Application for Removal or Variation of a Condition following Grant of Planning Permission or Listed Building Consent

Demolition of existing dwelling & erection of 8 apartments.

PL/2021/02465/PPFL

176 Tanworth Lane

Proposed Side Elevation (Left)
1 : 100

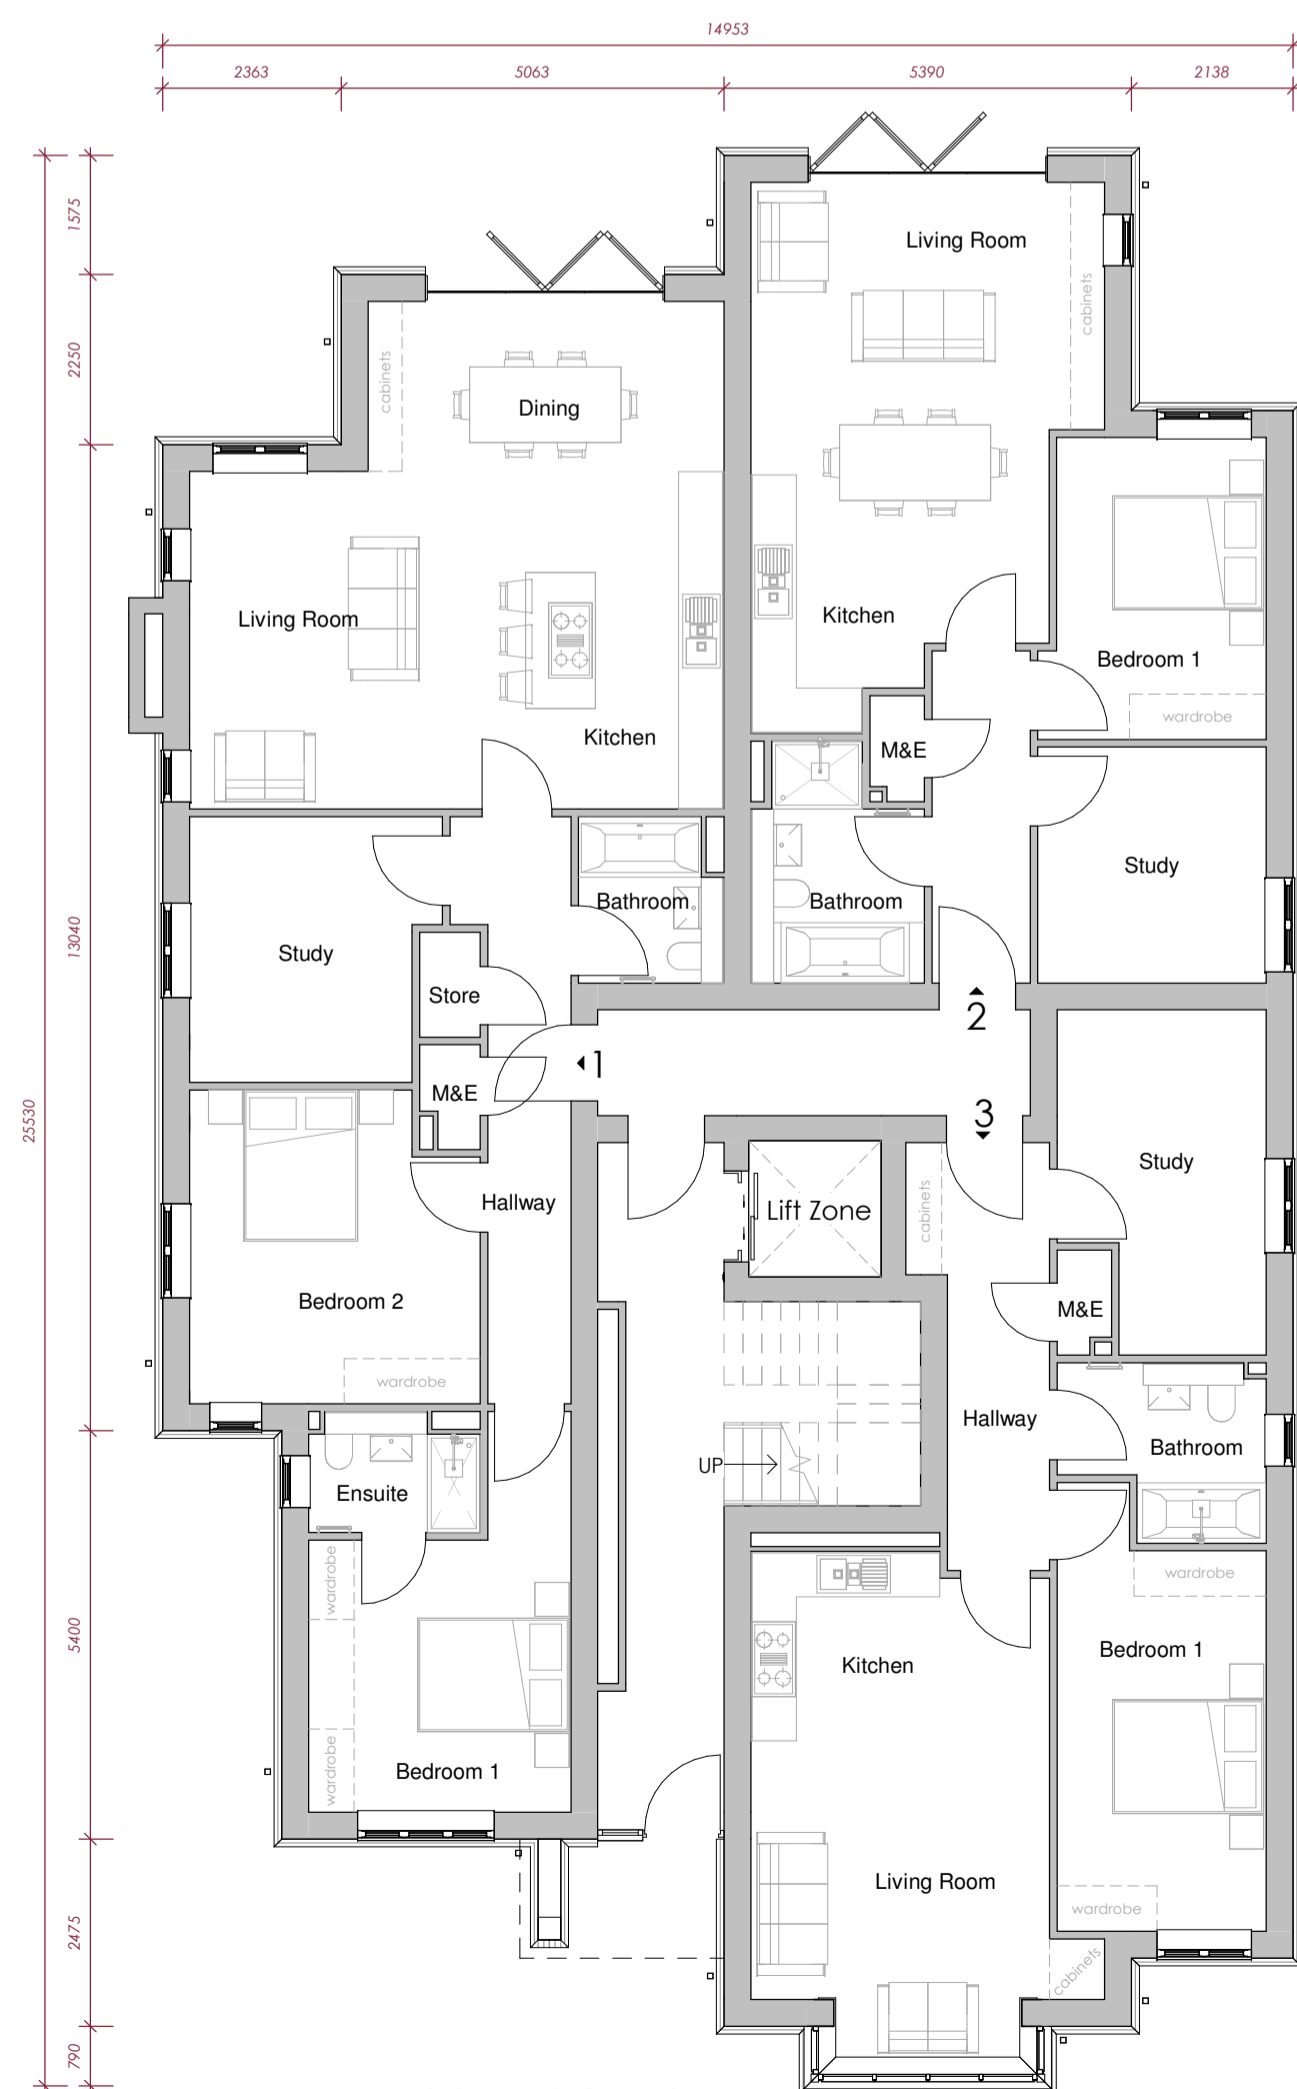
- 2 additional windows have been added to the left side elevation on the Ground Floor & First Floor.
- Updated schedule of materials showing a change in the PVC windows from white to Agate Grey.
- Solar Panels have been added on the roof in line with requirements to comply with the Part L Regulations.
- Details of the Entrance Gate.

Seeking approval of the new proposed plans & elevations which include the 2 additional windows & the solar panels.
